**FINAL DRAINAGE REPORT
FOR
LOT 5 OF CLEARWAY
EL PASO COUNTY, COLORADO**

SEPTEMBER 2022

Project #44-042

PCD Project No. PPR-22-034

Nyloplast 2' x 2' Steel Bar / MAG Grate Inlet Capacity Chart

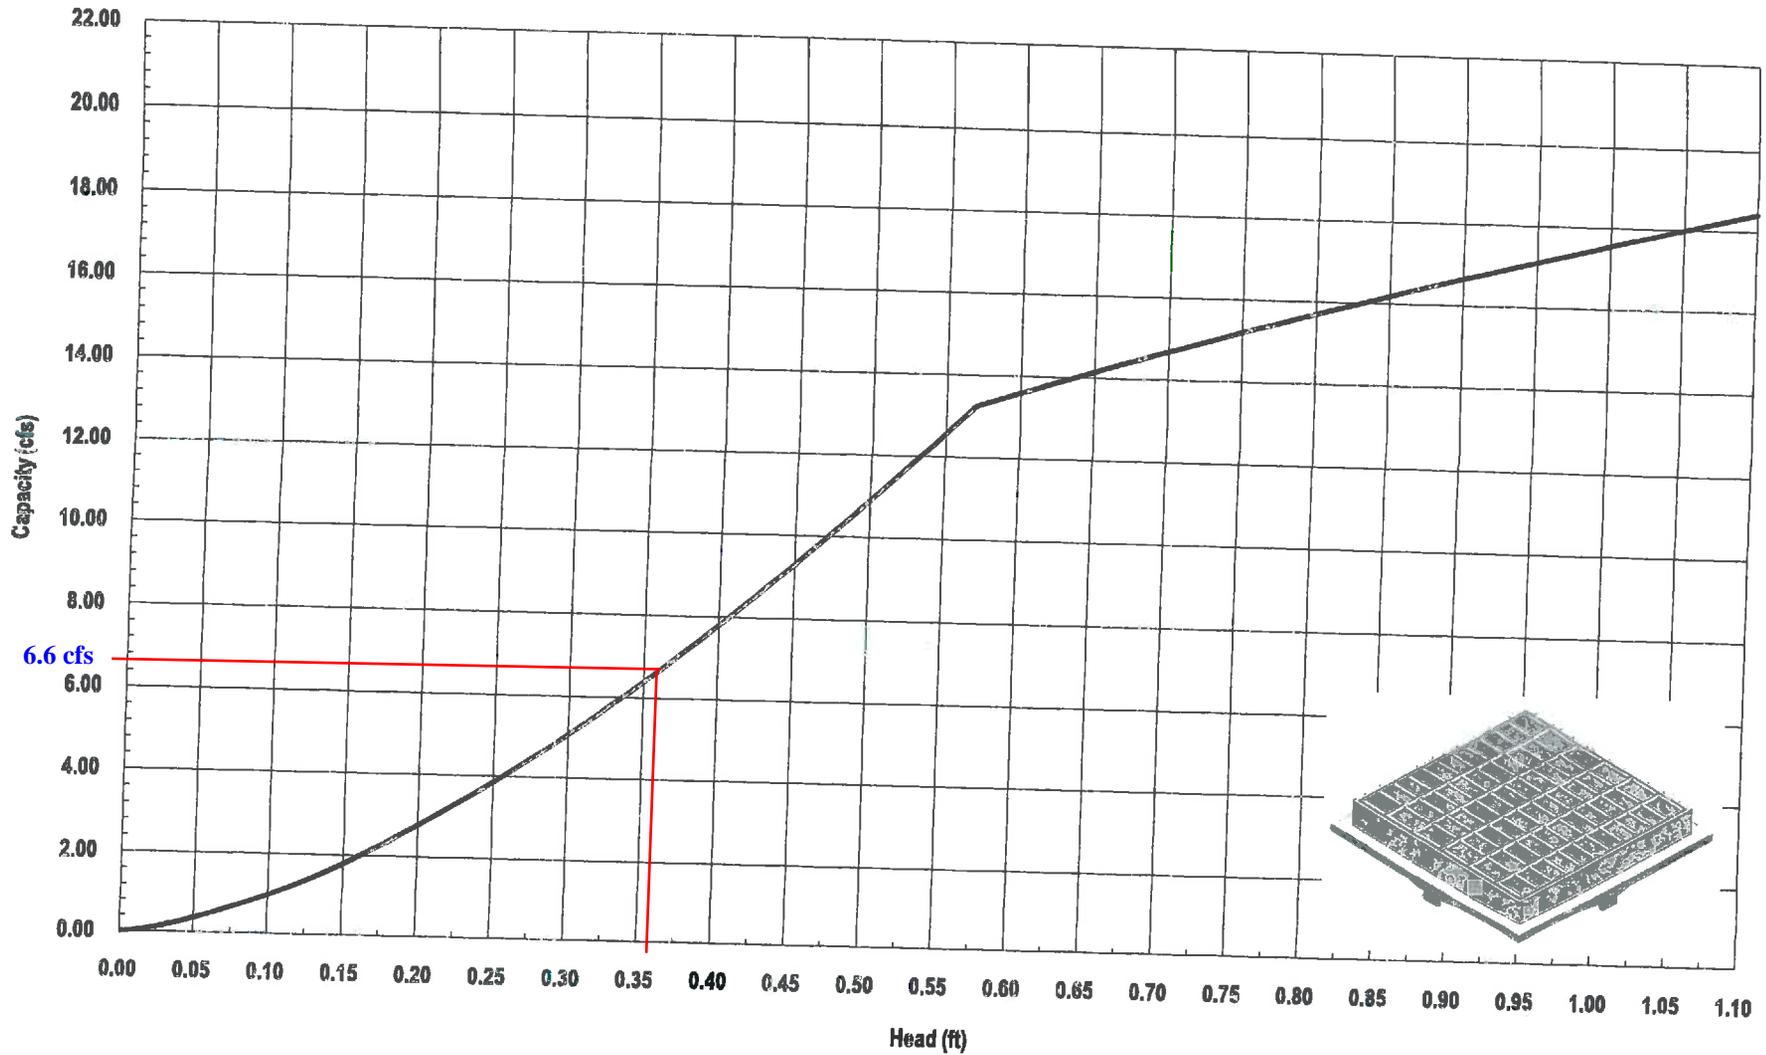
A 24" nyoplast grate inlet is shown on the plans. Please revise accordingly.

corrected
